DEPARTMENT OF PUBLIC WORKS

MEMORANDUM

SUBJECT: SE-22-00054 Casto

Public Works SEPA Application Comments:

**BOUNDARY AND TOPOGRAPHIC SURVEY  
LOT 1, WALMER SHORT PLAT**  
WITHIN THE SW1/4 OF THE SE1/4 OF SECTION 07, TOWNSHIP 19 NORTH, RANGE 16 EAST, W.M., KITTITAS COUNTY, WASHINGTON

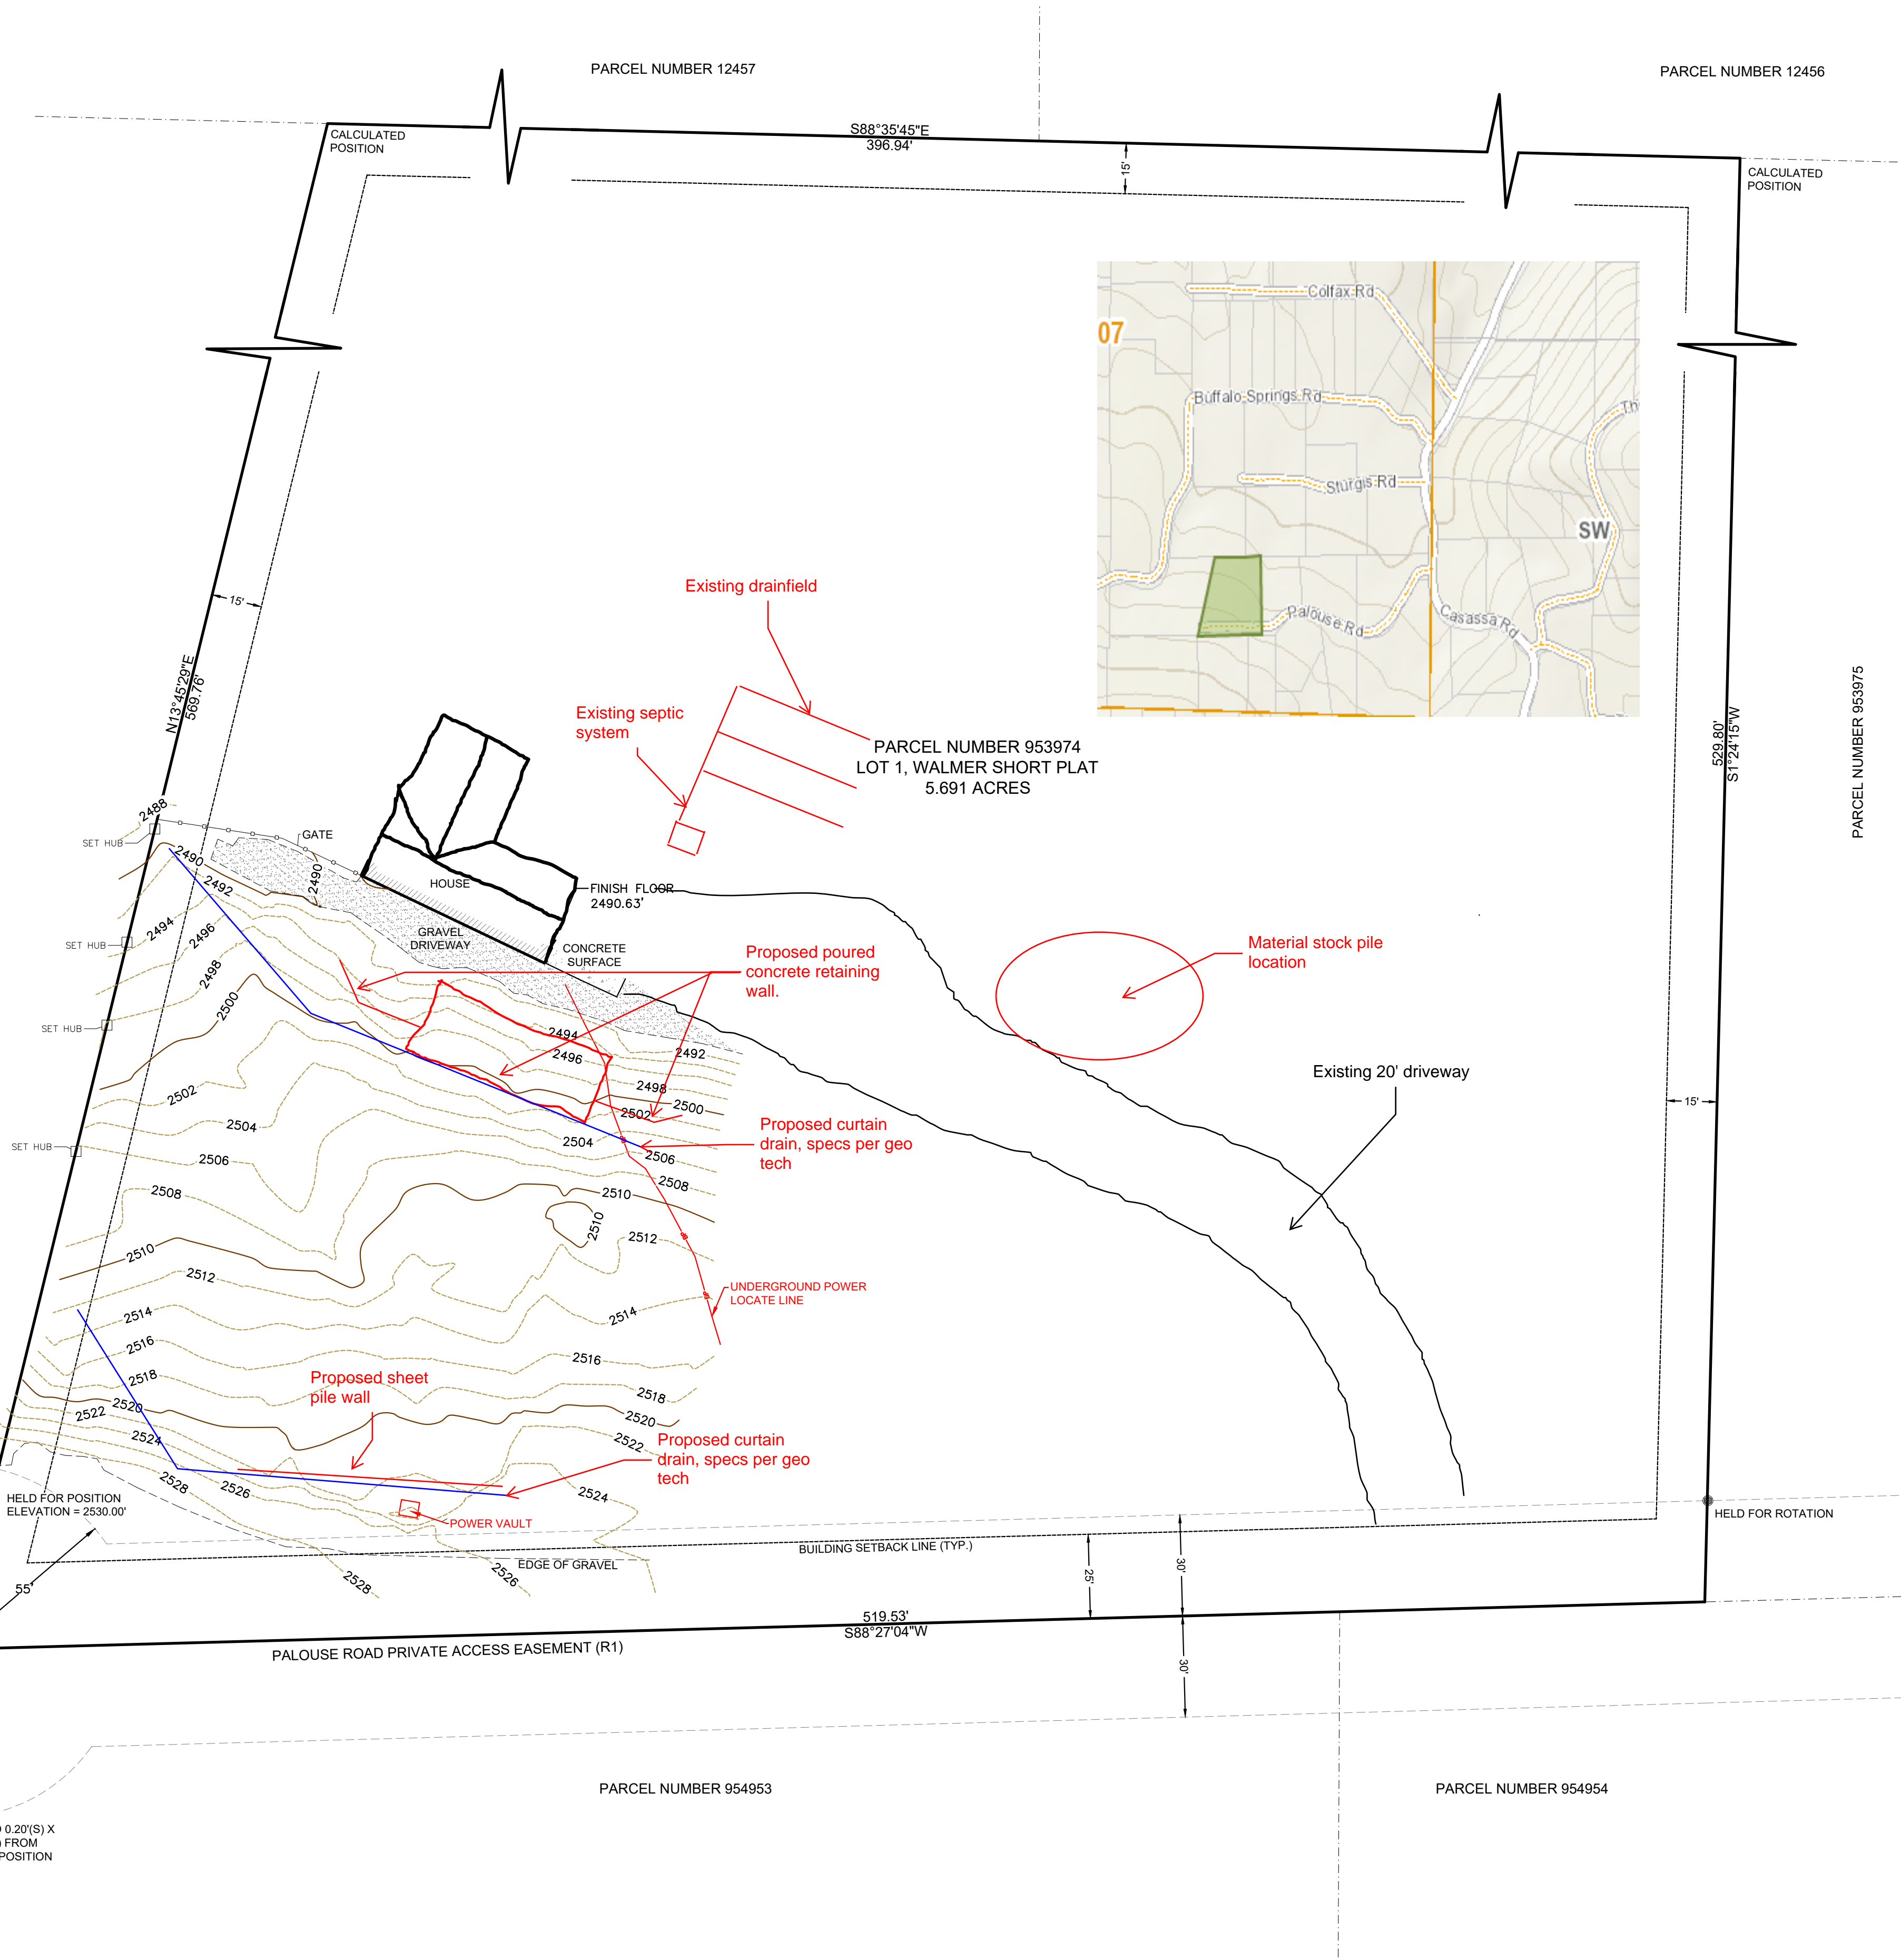
- 1. In the application documents, the applicant appears to have revised the work of a Licensed Land Surveyor, presumably without permission. Public Works recommends delaying any approval of this SEPA application until such time the submitted materials are revised to meet the requirements of WAC 196 or Public Works receives confirmation from the Licensed Land Surveyor that the submitted site map is his work.***
